KITTITAS COUNTY

MEMORANDUM

TO: All Staff
FROM: Justin Turnbull, County Surveyor 
DATE: January 23, 2018
SUBJECT: County Survey Review of Short Plat 17-00003 (Naneum Rd)
(CDS refers to this as 17-00003 Mitchell)

NANEUM ROAD SHORT PLAT  
 PART OF SECTION 33, T. 18 N., R. 19 E., W.M.  
 KITTITAS COUNTY, WASHINGTON

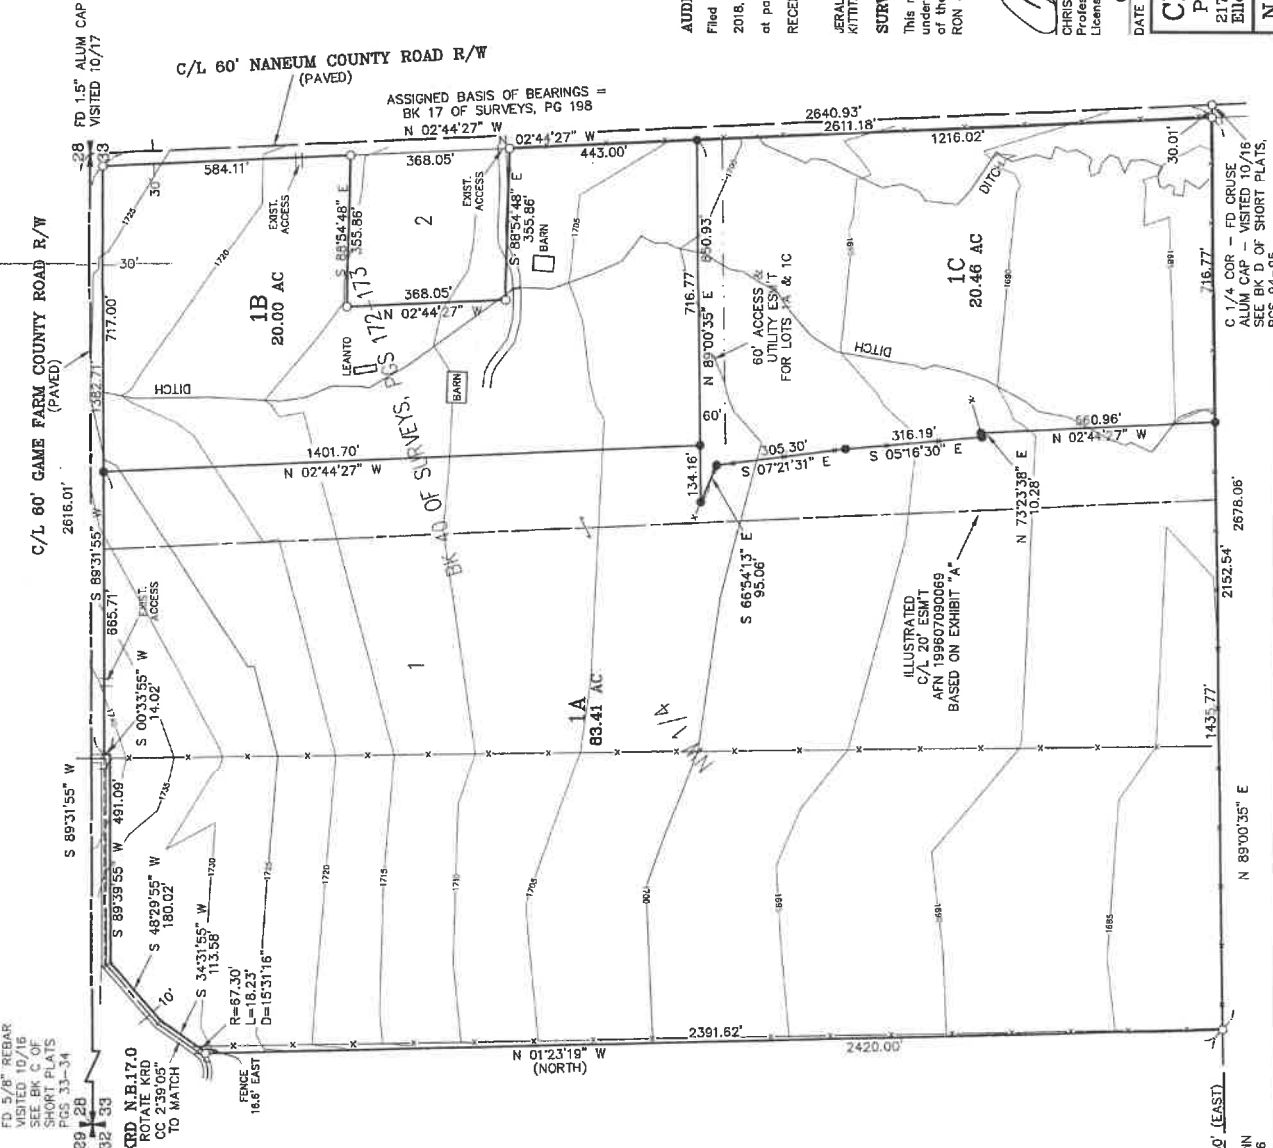
1. No Lot closures provided as part of the submittal, please provide prior to final approval.
2. No Title report included as part of the submittal, please provide prior to final approval.
3. Where elevations or contours are shown, a note stating the vertical datum used is required. If the elevations are assumed, a benchmark (or solid unmistakable feature), with elevation shown shall be noted on the face of the map.
